Application No: FP/70/21/PL
Site Address: Kenwood Court 6 The Midway Felpham PO22 7EZ
Description of works: Erection of a car port and rearrangement of existing parking spaces. This application is in CIL Zone 4 (Zero Rated) as other development.

Thank you for your internet representation made on 19th May 2021 which has been recorded as an objection with the comments as follows:

**PROPOSED CAR PORT
PLANS AND ELEVATIONS**

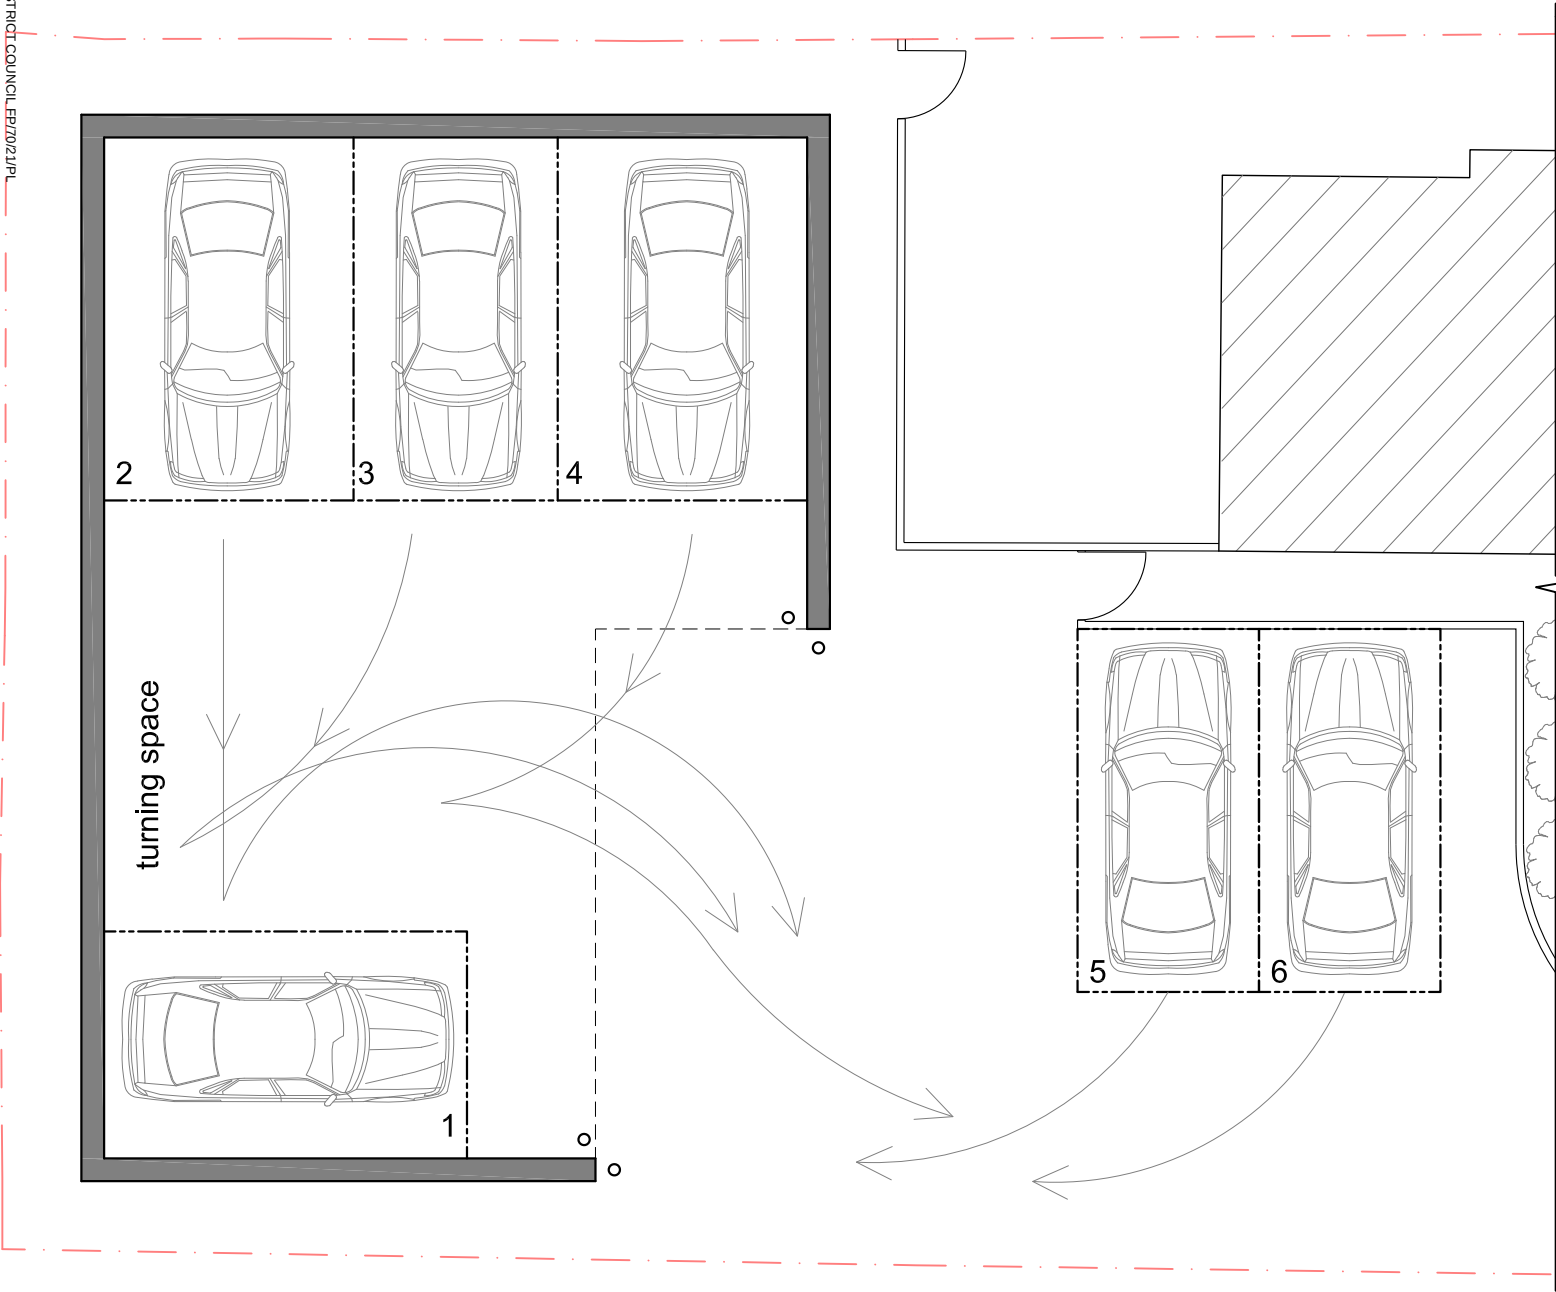
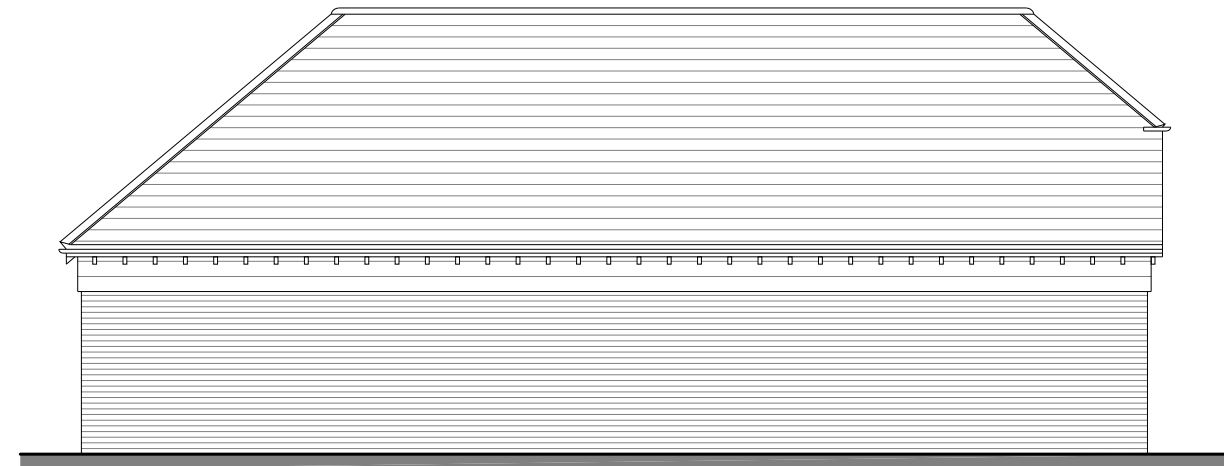
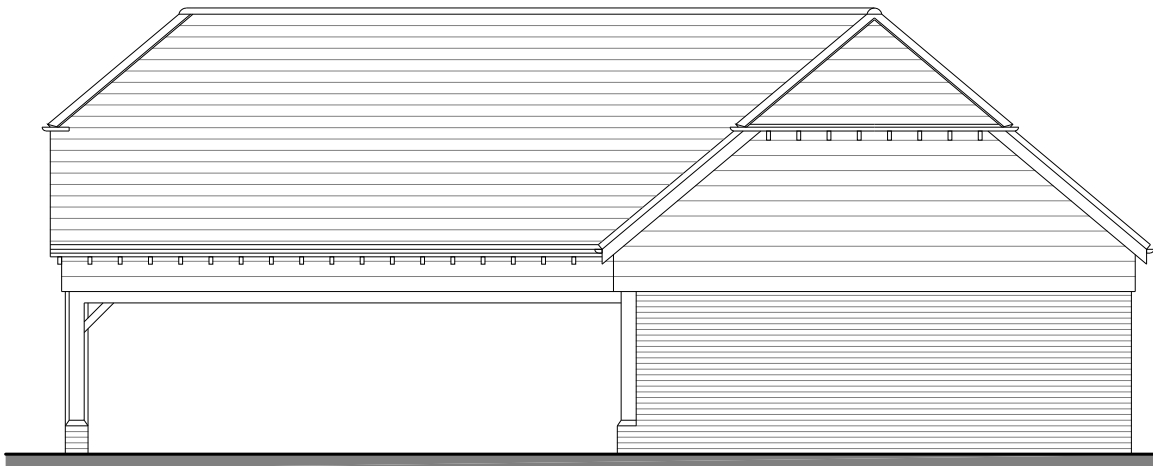
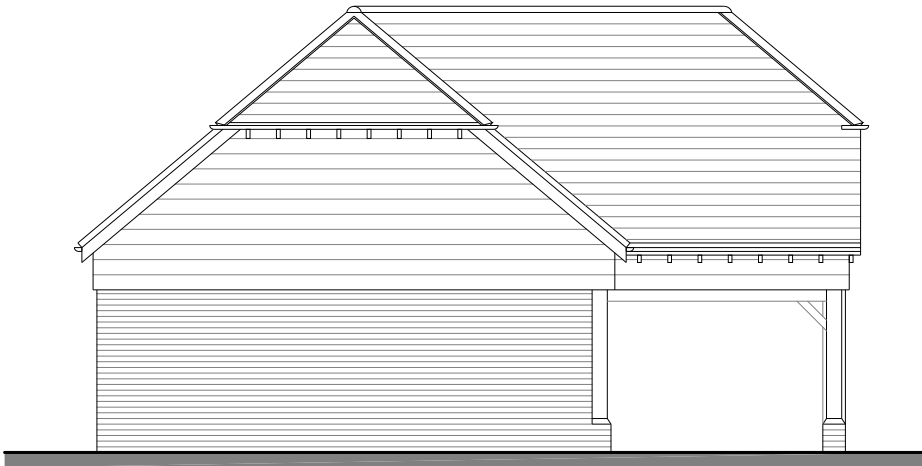
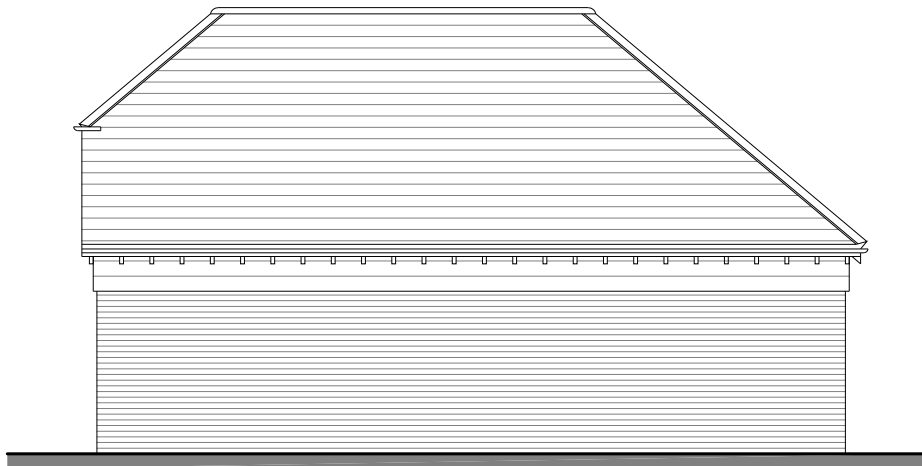
- 1/ Size, it's huge, it's too big. It's supposed to be a car port, but it's the size of a house. A car port doesn't need to be 7 or 8 meters high.
- 2/ Style, it's the same design, style and shape of a proper house.
It's basically a barn type building with an open side for vehicle access but the design is obviously intended to be converted to a proper residential house in the future.

- 6/ This proposed building will have a severe negative impact on the lives of myself, my elderly mother and my neighbors.
- 7/ This huge structure will block out a lot of light from my small annex property at the rear of Kenwood Court.

- 8/ This proposed building will directly overlook my property. Myself and my elderly mother will literally be living under its shadow.
- 9/ The proposed building's wall on the south, west and north will have a very narrow gap between them and

neighboring fences. These gaps will fill with wet leaves and rubbish over time. The area will become damp and smelly and attract nats and midgis.

10/ The building's east facing wall will be directly outside my back gate and will create a very small alley way along my back fence.

I'd literally come out of my back gate and be facing a brick wall.

My back gate and side path are the fire escape route for myself and mother, and the tenants of Kenwood Court should they need it in an emergency.

The proposed new layout comprises our safety. If a bicycle or bin was left in the new alley way it would be completely blocked.
